HASH-00-SD-BC-RP-0001

BCA ASSESSMENT REPORT

Hurlstone Agricultural High School
(Hawkesbury)

October 2017

DRAWING
Level 2 FFE - Overall

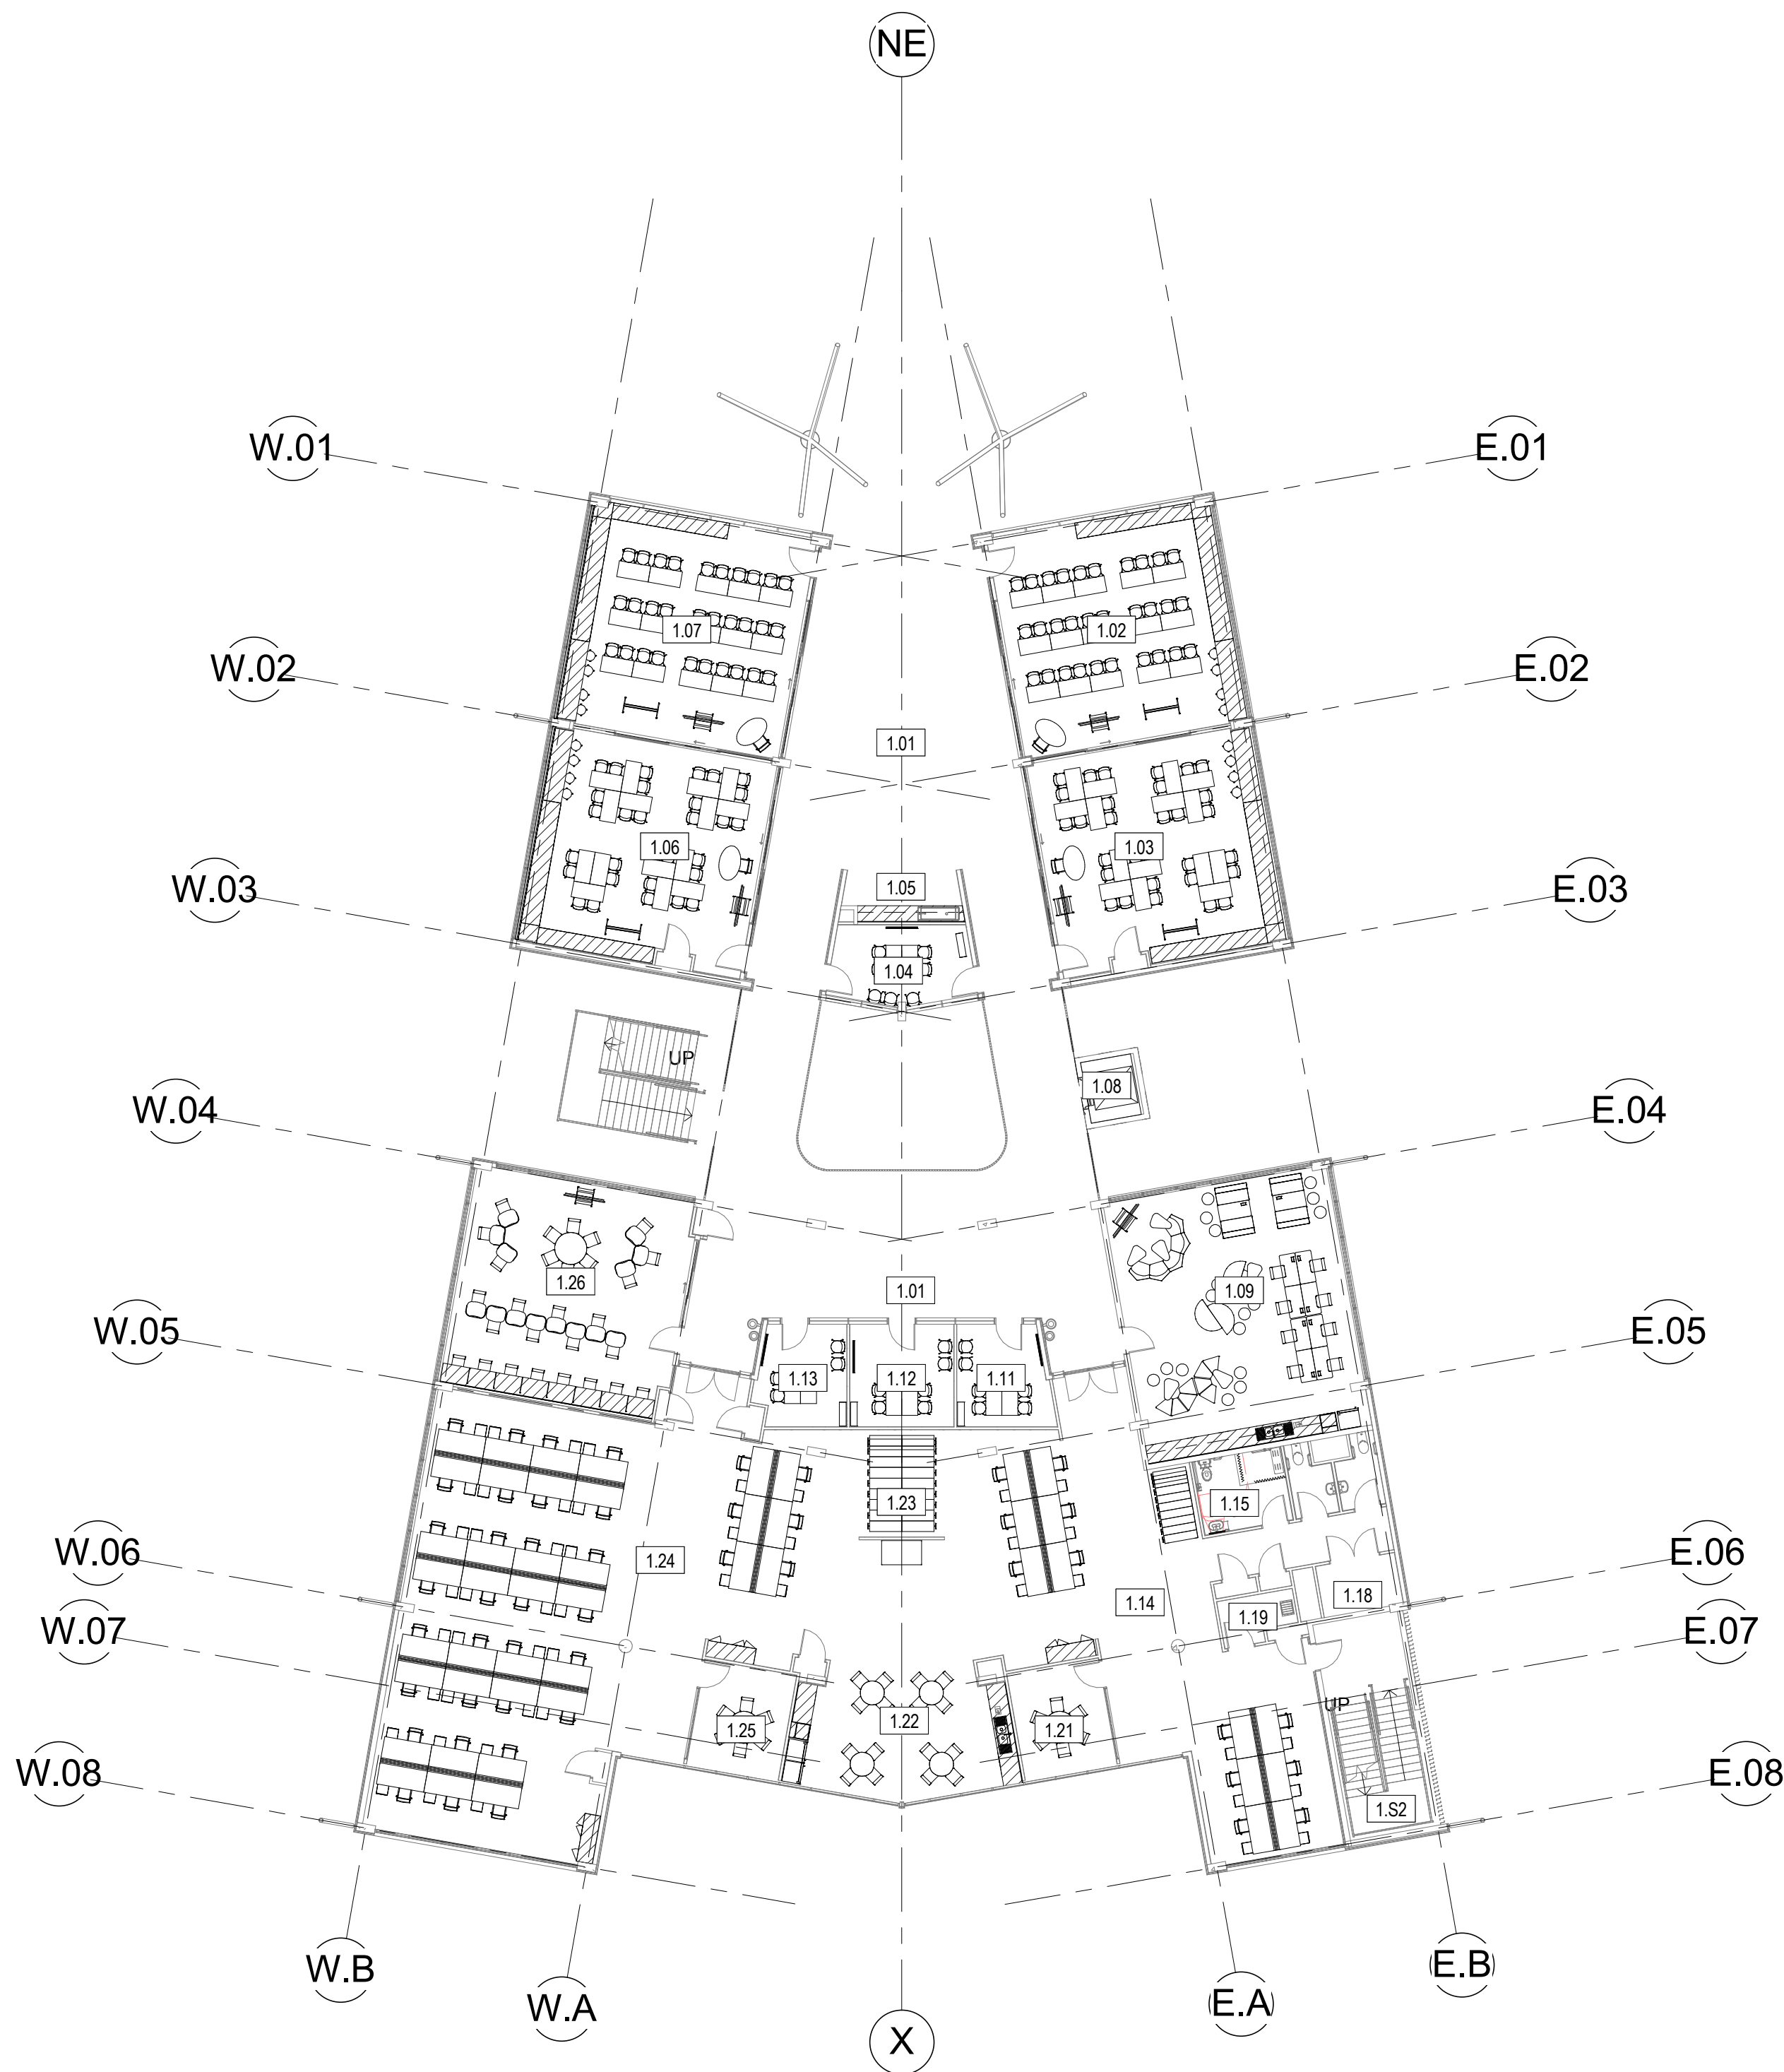
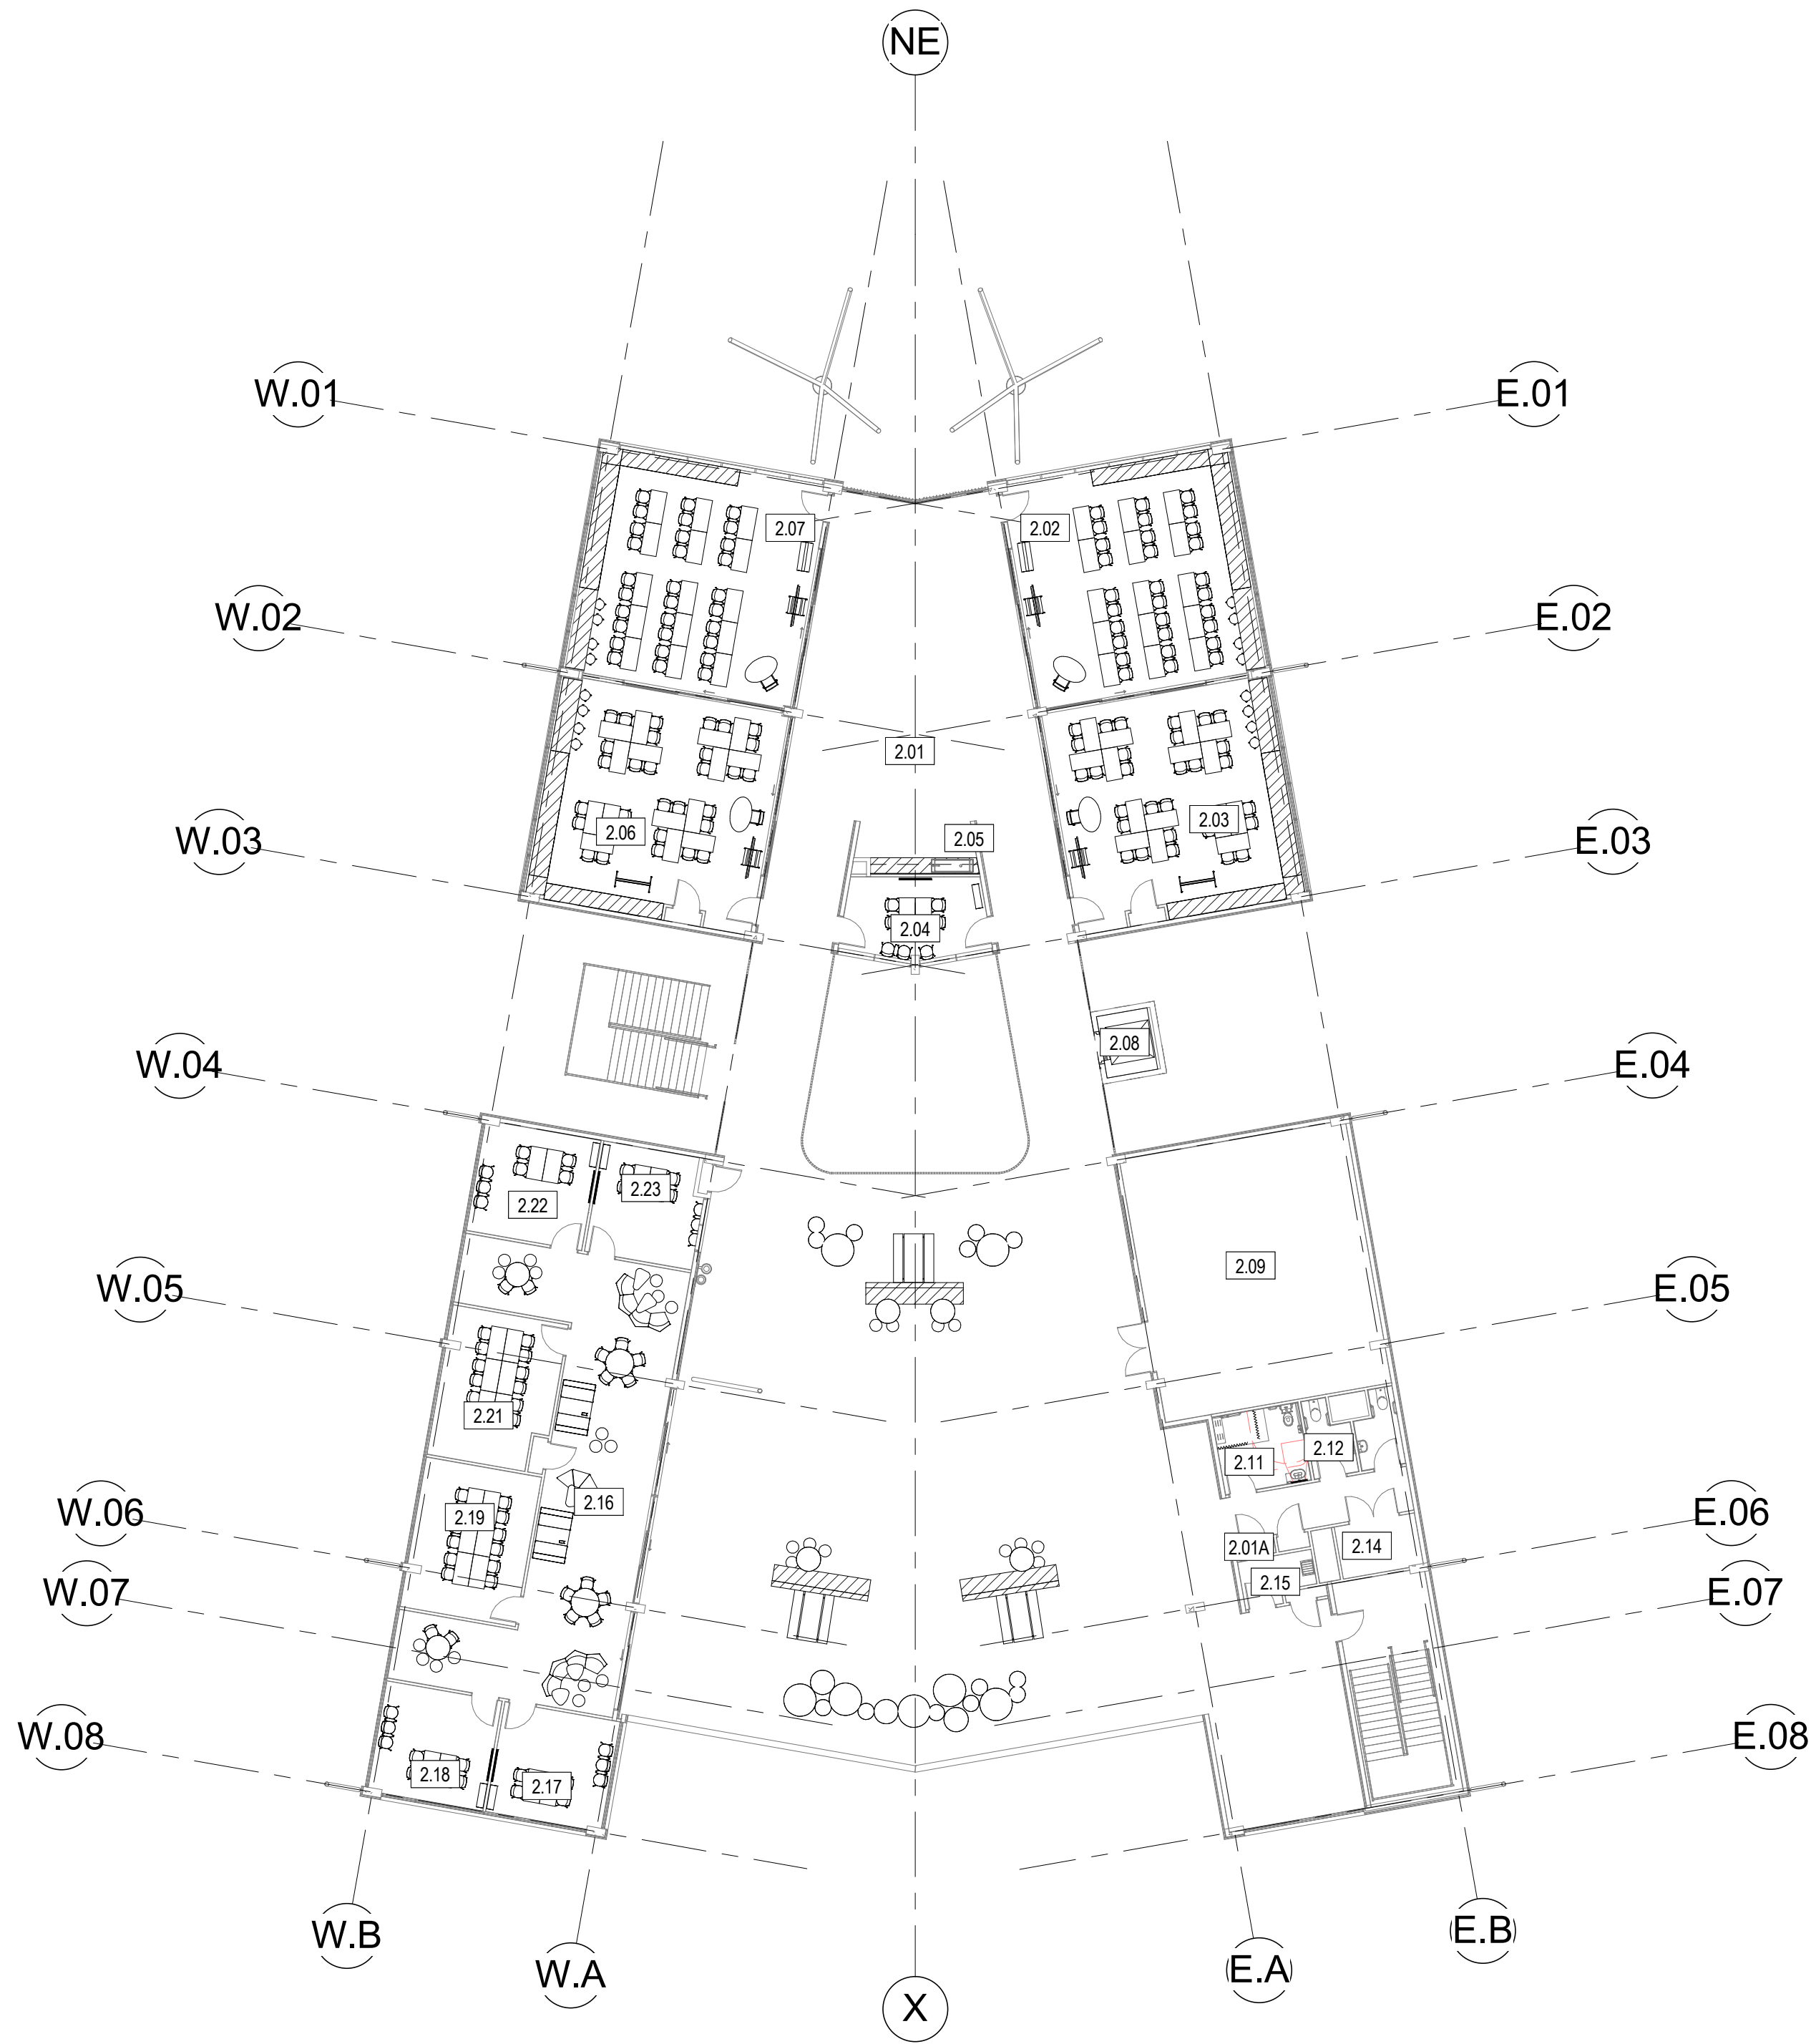
5.	Part F2	Separate male and female staff sanitary facilities need to be provided within Building 2 this will include the provision of separate washbasins. Accessible sanitary facilities within Building 1 are not located at the same bank as the ambulant facilities in at least 50% of occasions.
